CITY OF MERCER ISLAND

Re: Review Letter for CAO18-003 - Critical areas Determination
Regarding: possible piped watercourse and the type IV wetland located at 8114 West Mercer Way Mercer Island, WA 98040; Parcel ID: 33585-00974

date July 26, 2018
to Lauren Anderson, Assistant Planner
from Jessica Redman, Ecologist
subject Lee Residence (CAO18-003) Critical Areas Review

Figure 4. Site Plan Showing Proposed Buffer Reduction and Addition Areas

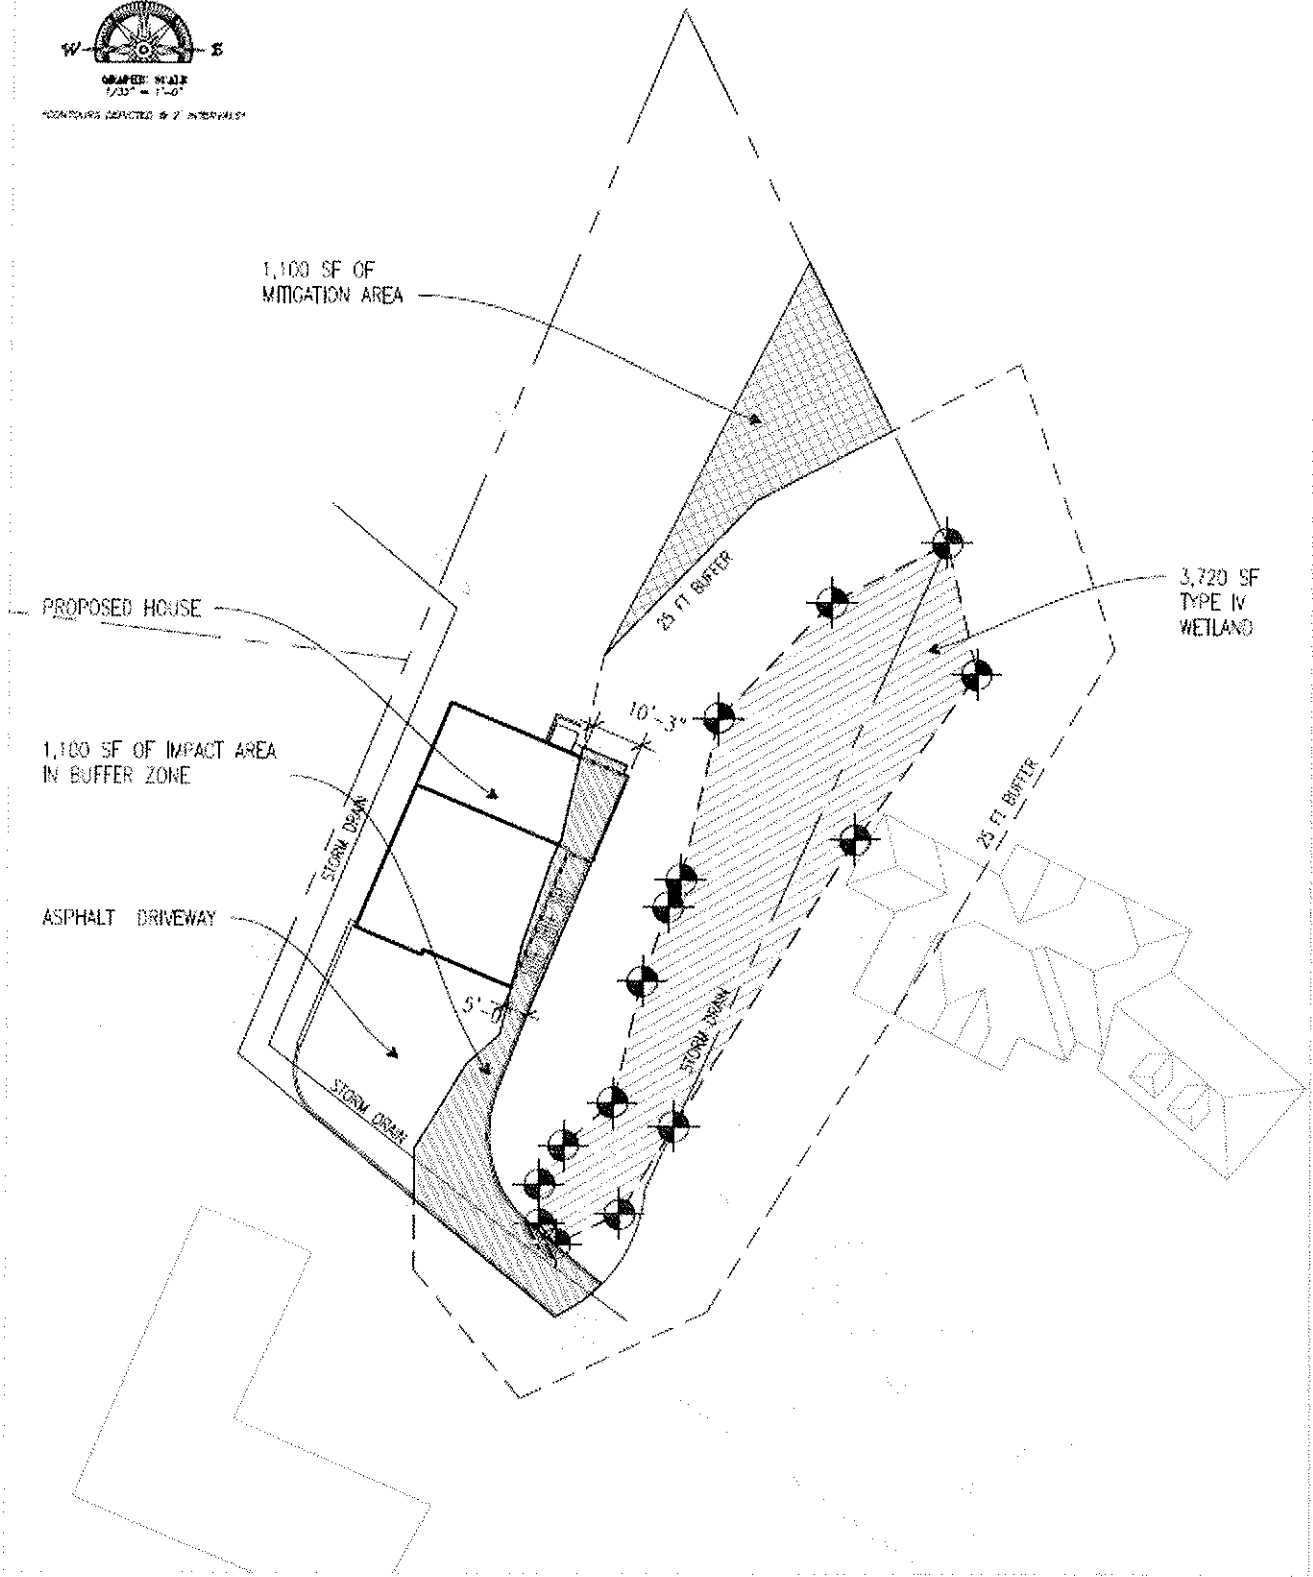
4. Site Plan. Please revise the site plan to include the following items:
- a. Indicate the original (35 foot) and reduced (25 foot) Type IV wetland buffer.

- b. Indicate the location and classification of the 200 sf wetland and associated buffer.
 - c. Please remove the reduced buffer off-site, as this application is for 8114 West Mercer Way only.

- d. Please only show the reduced buffer for the house and driveway. No development is proposed in the upland area and consequently there is no need for a buffer reduction.

- e. Indicate the extent of the steep slope on-site, as the wetland buffer cannot be reduced in a steep slope. This can be illustrated with hatching on the site plan, based on the underlying topographic survey. MICC 19.16 defines steep slope as the following: *“any slope of 40 percent or greater calculated by measuring the vertical rise over any 30-foot horizontal run. Steep slopes do not include artificially created cut slopes or rockeries.”*

- f. Indicate the easements on-site and provide the recording numbers.
 - g. Clearly label the property line and dimensions.
5. Critical Areas Study.
- a. In the Critical Areas Study please clearly state how the new driveway complies with MICC 19.07.030(6):

- iii. Delineation of critical areas; Please locate the 200 square foot wet area that was mentioned in the introduction of the wetland delineation report and please indicate the location on the site plan.

9. Please state why the driveway, stairs, and northeast portion of the house was placed within the reduced buffer.

Can the above items be located outside of the reduced buffer to reduce impacts? There will be temporary construction impacts from excavation and installation of the house, stairs, and driveway that will encroach further into the reduced buffer. A 4-5-foot setback from the buffer should be provided to mitigate construction impacts and for long-term maintenance. Long-term maintenance includes maintenance of the house long-term such as painting and accessing the backyard.

Figure 5. Planting Areas to Provide Buffer Restoration and Enhancement

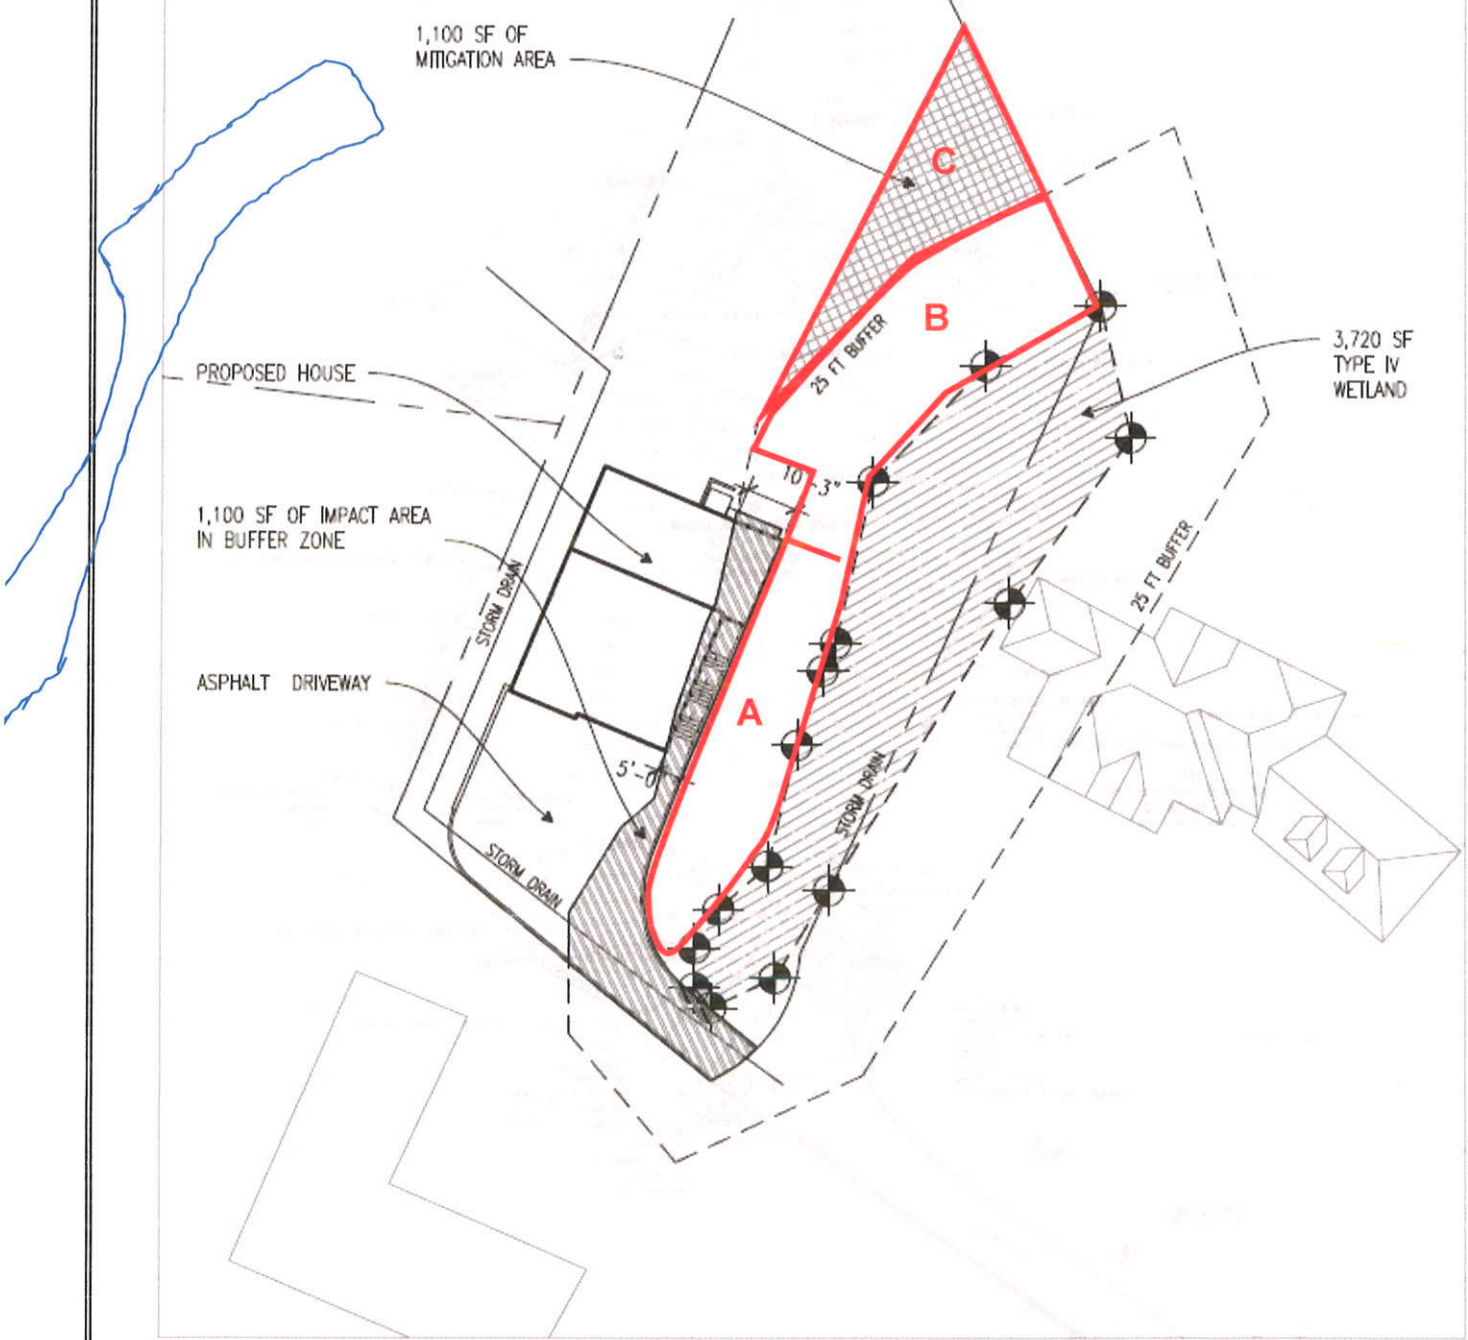
- i. Location of existing trees and vegetation and proposed removal of same;
 - ii. Mitigation proposed including location, type, and number of replacement trees and vegetation (planting plan);

loss of function. In addition to the proposed buffer addition and buffer enhancement, we recommend wetland enhancement in the southern portion of the wetland where reed canarygrass is dominant. The hand removal of invasive vegetation (i.e. Himalayan blackberry and reed canarygrass) and the subsequent installation of native plants within this area would offset the impacts to the reduced buffer as well as reduce the impacts of the proposed driveway. We recommend the Wetland Mitigation and Monitoring Plan be revised to include wetland enhancement in the southern portion of Wetland A.
